Subject: RE: Kings Close Yapton

Thank you for sending the report that details contamination of the soils and groundwater. I can comment that;

Please could you review the document in order that we can move towards approval and agreement on the remediation strategy and ultimately the discharge of associated planning conditions (15,16 and 17 of application ref Y/22/14/)

TITLE: Exploratory Hole Location Plan

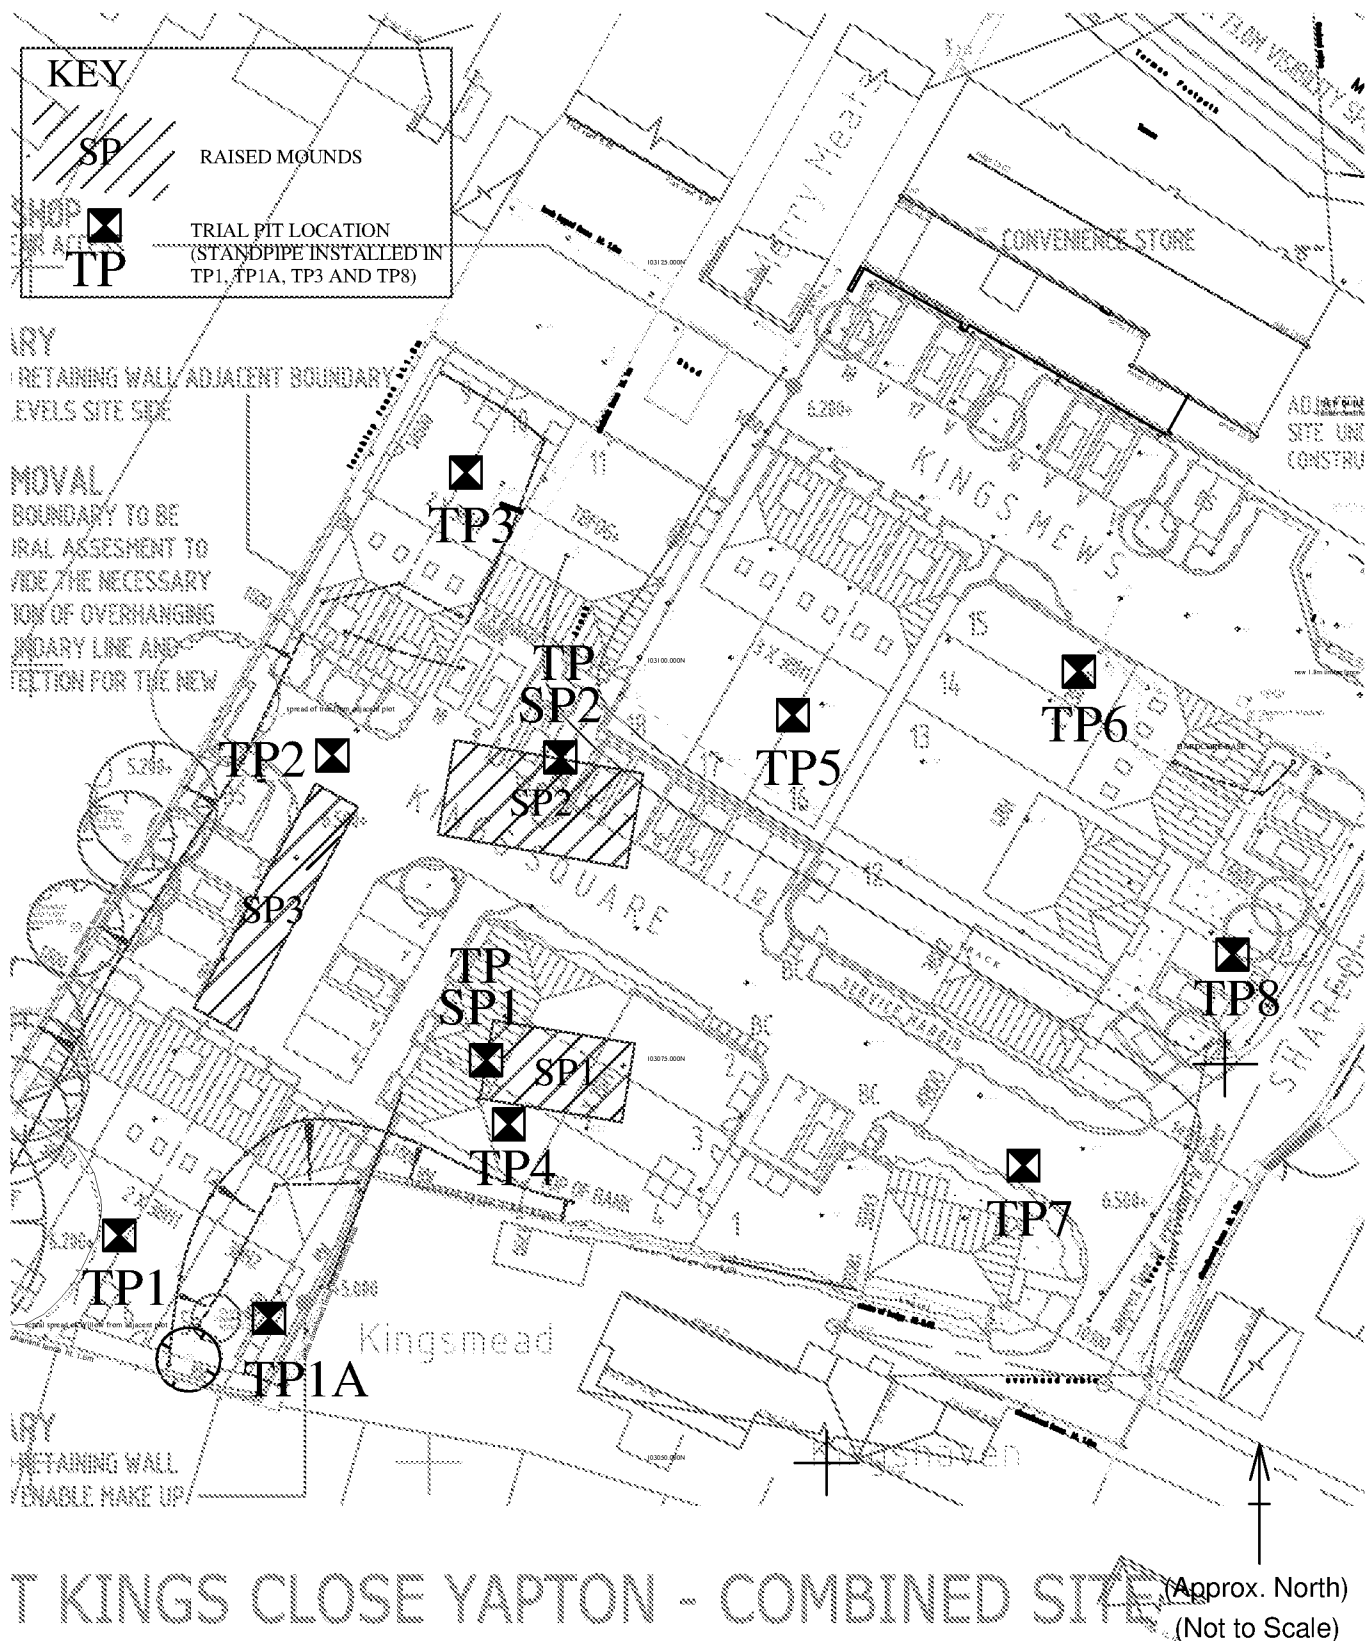
From a groundwater perspective (Simon Deacon may comment on separately) am unsure as to what depth the free phase contamination in TP8 is at, or the depth of GW in WS1-3 that surround TP8. There is no mention as to whether this will impact the properties built above, but there is the recommendation to look for sources of this contamination when excavations take place as part of the development. A hydrocarbon membrane should be used even if GW remediation takes place.
